TRAFFIC IMPACT ASSESSMENT (TIA)

**Proposed Waste Management facility
2-4 Hale Street, Botany**

Reference: 23.464r01v13
Date: March 2025

2.1 DPHI RFI

Notes:

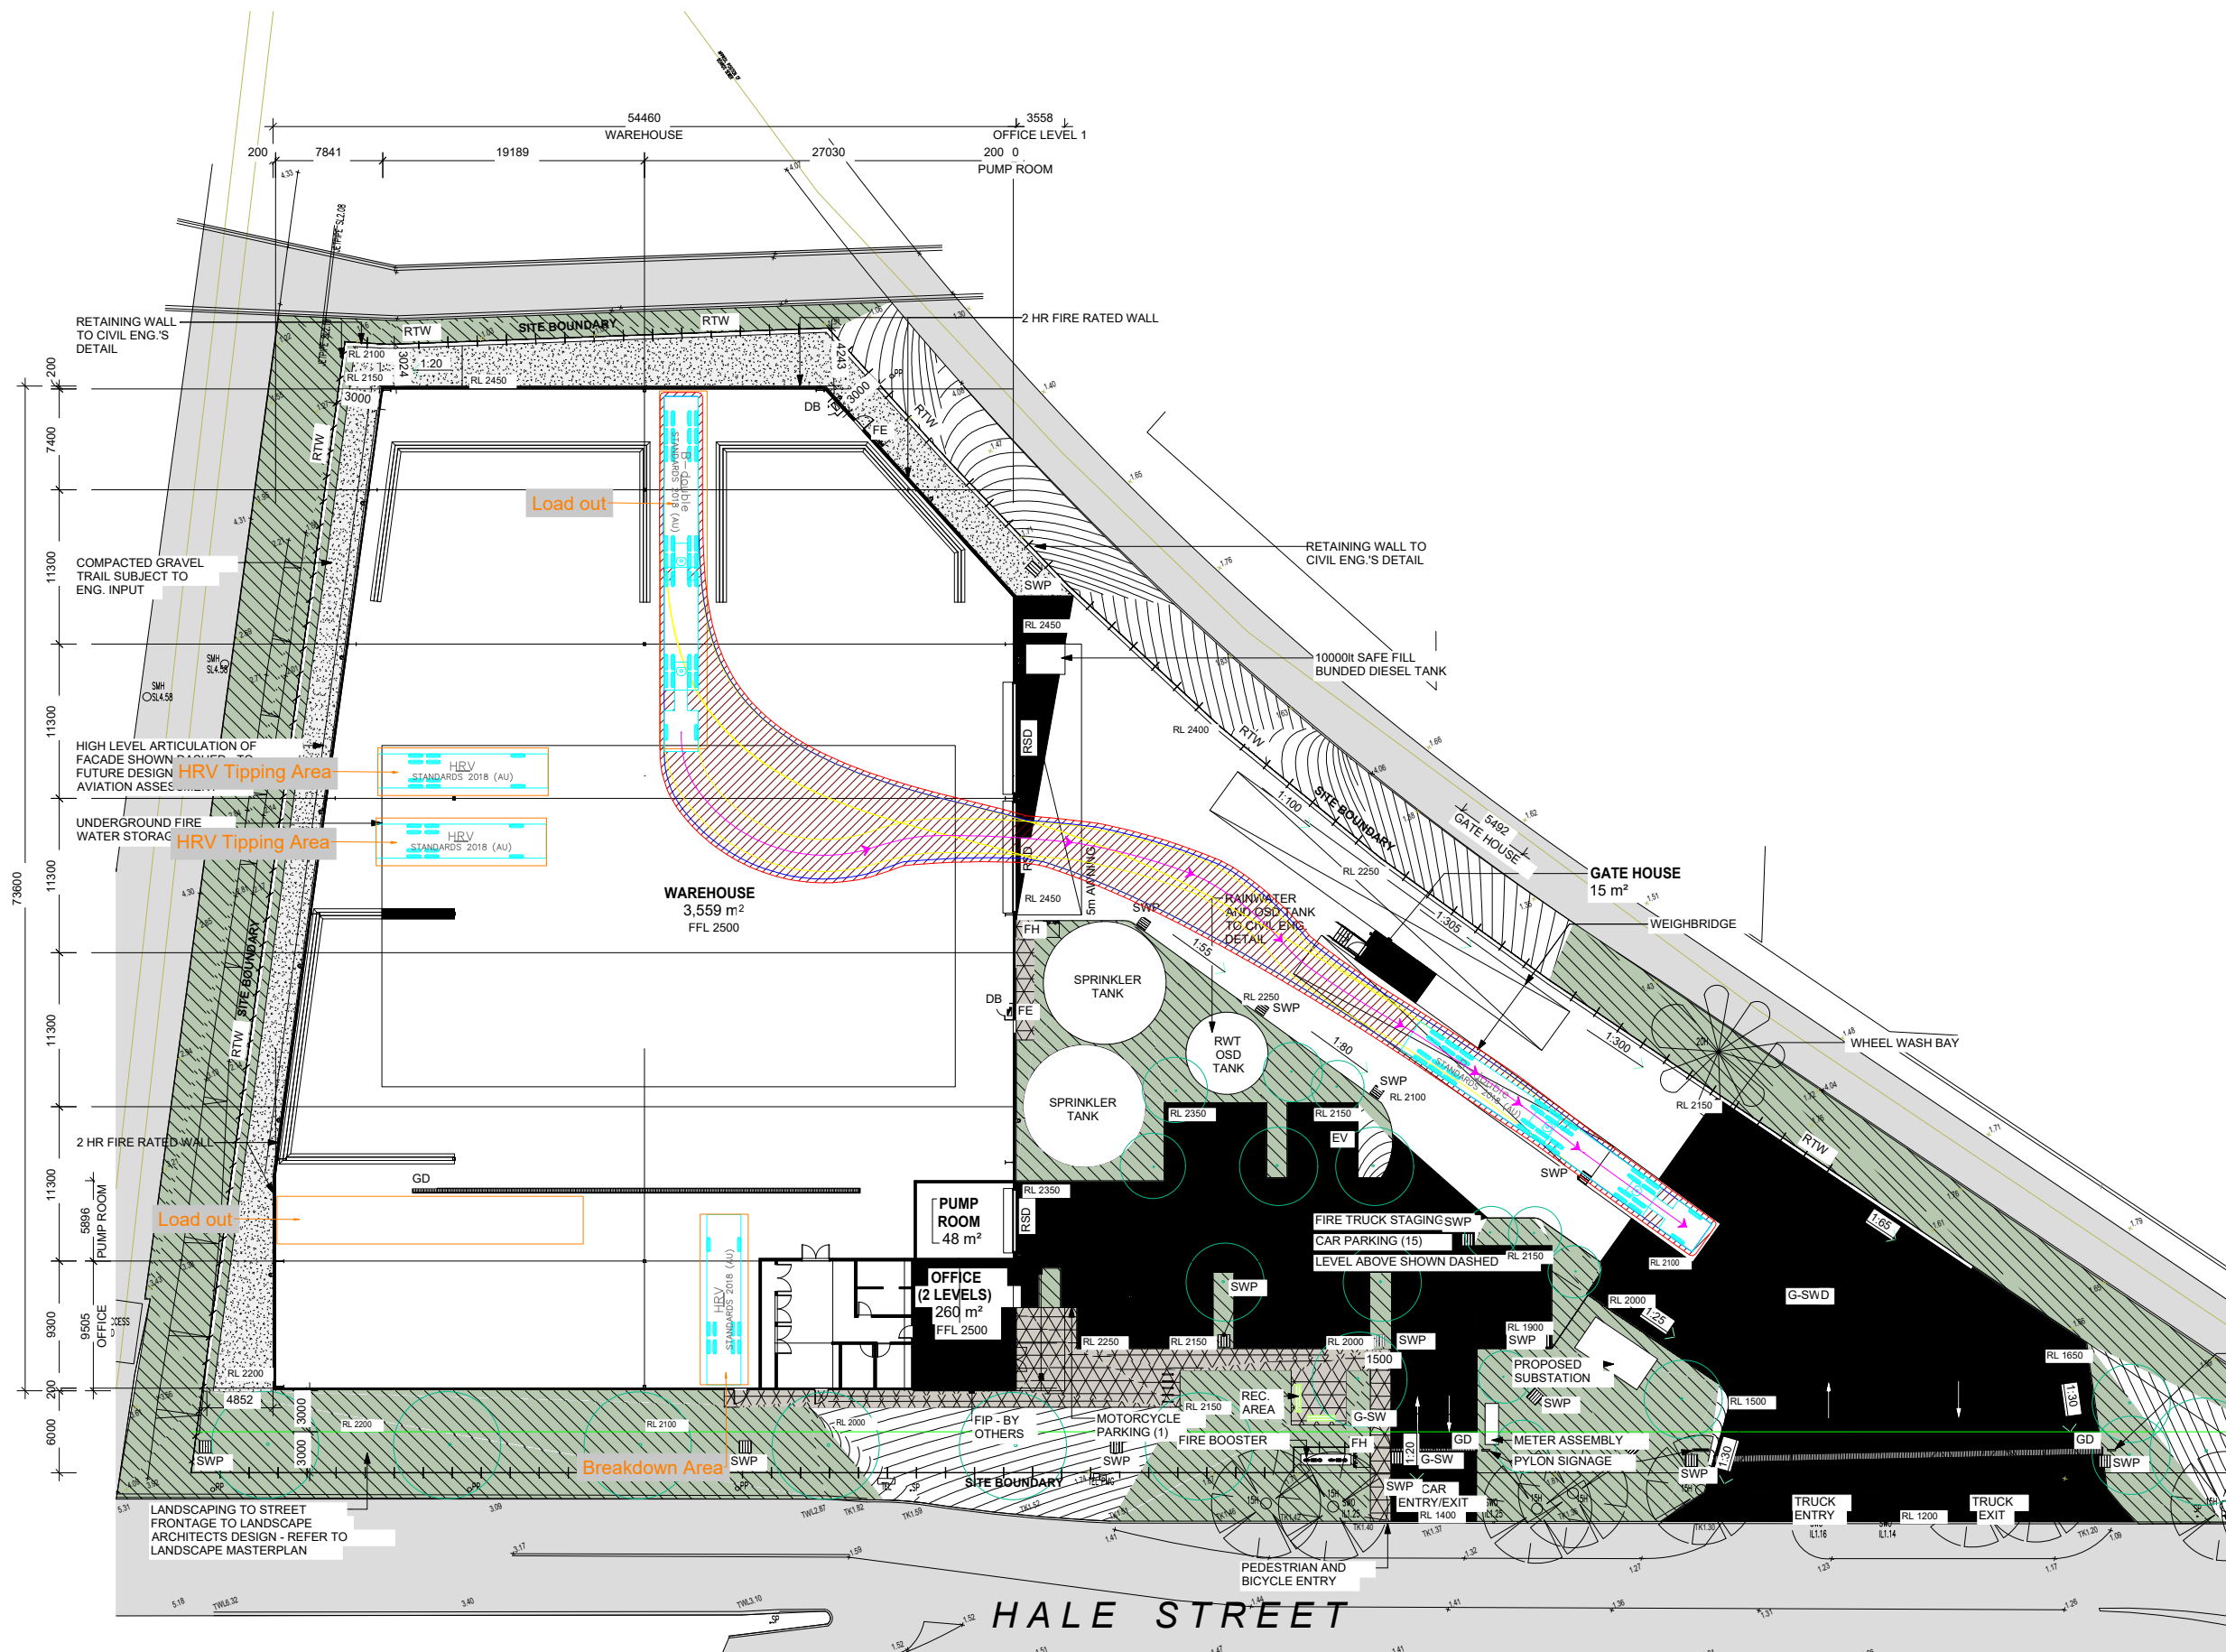
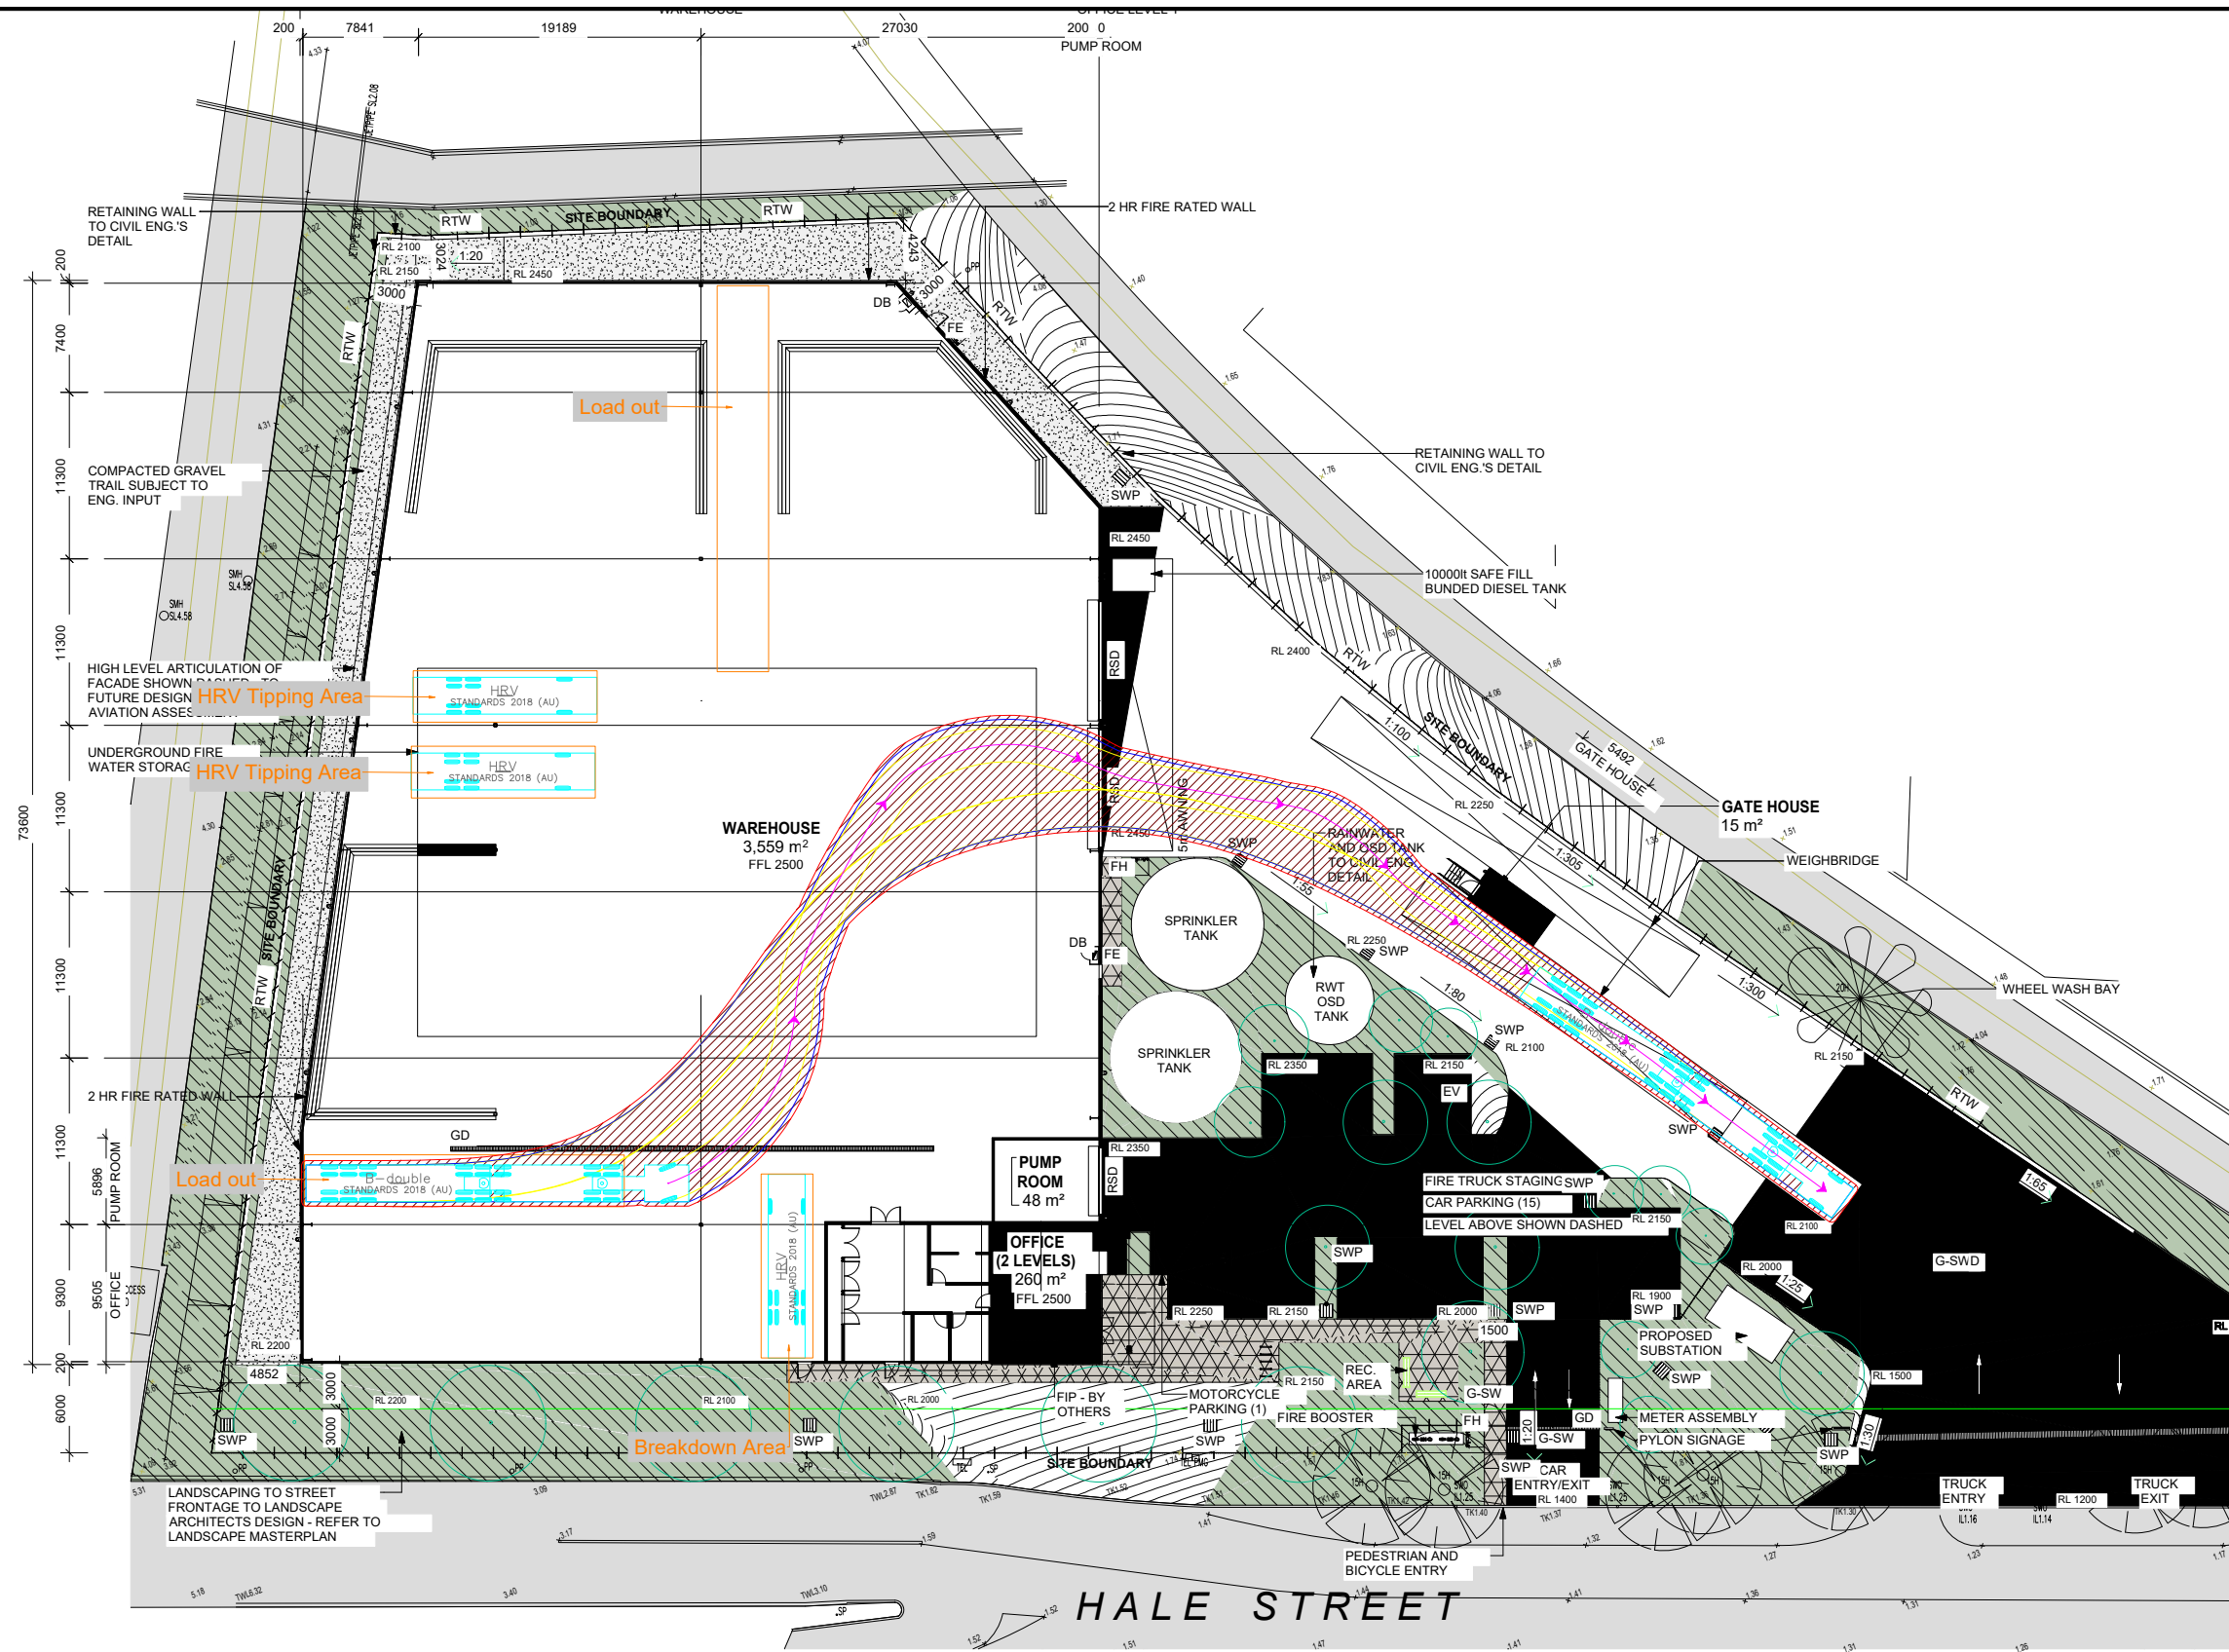
<u>Swept Path Analysis</u> The swept path analysis for the site access driveway provided at Appendix D of the TIA is unclear and indicates there may be conflict between two B-doubles travelling eastbound and westbound on Hale Street. Recommendation: Revised swept path analyses are required for 20 metre articulated vehicles and B-doubles accessing the site that clearly demonstrates the centreline of Hale Street will not be crossed and there will be no conflict with on-street parking. All line marking on Hale Street must be clearly marked.	Swept path analysis have been updated with recent Nearmap aerial georeferenced in the background clearly demonstrating 26m B-double vehicles will be able to ingress and egress the site satisfactorily in accordance with AS 2890.2 (2018).
<u>Daily Heavy Vehicle (HV) Movements</u> Section 6.10: Truck Frequencies of the TIA outlines the anticipated truck volumes for the development. It is not clear how these vehicle numbers have been determined. Bayside Council has also raised several queries regarding the traffic generation analysis. Recommendation: Additional information is required to justify the predicted truck volumes, including the breakdown of vehicle types.	TIA has been updated to provide detailed calculations on how the anticipated heavy vehicle trip generation associated with the proposed development has been estimated including a breakdown of the vehicle types, refer to Section 9.

Concerns are raised regarding the swept paths of 20m long AV and 26m B-Double conflicting with on-street parking on the southern side of Hale Street. The appendix D swept paths shall be revised with that southern on-street parking shown as minimum 2.4m wide from face of kerb. Swept paths can be undertaken on the assumption that parking on the northern side will be removed. Truck movements including 300mm clearance are not to impact on-street parking.	• Swept path analysis have been updated with recent Nearmap aerial georeferenced in the background clearly demonstrating 26m B-double vehicles will be able to ingress and egress the site satisfactorily in accordance with AS 2890.2 (2018).

The appendix D swept path analysis details an unrealistic kink in the truck wheel movement near the car entry/exit. See figure below.	All swept path analysis has been undertaken using the latest version of the industry leading software AutoTURN Pro, we can provide animated swept paths in a video file or live demonstration to Council upon request to prove our professional integrity.
The swept path analysis shall be revised to better depict all line marking on Hale Street. Vehicles shall not cross over the road centreline.	Swept path analysis have been updated with recent Nearmap aerial georeferenced in the background clearly demonstrating 26m B-double vehicles will be able to ingress and egress the site satisfactorily in accordance with AS 2890.2 (2018).
The parking rate derived in section 7 of the traffic report is insufficient for this site. 1 car parking space shall be provided for each staff member in addition to the 4 visitor spaces. Additionally, given the swept paths and the two driveways proposed, the on- street parking on the northern side of Hale Street is effectively entirely removed by this development. The loss of public parking needs to be supplemented by the development.	- The proposed development has been amended to provide a minimum of one (1) car parking space per FTE staff in addition to the four (4) visitor spaces in accordance with Council's request. - It is unclear how on-street parking can be supplemented by a private development that is not open to the public notwithstanding the security and legal challenges if this was permitted to occur. - Refer to Section 8.6 of this report.
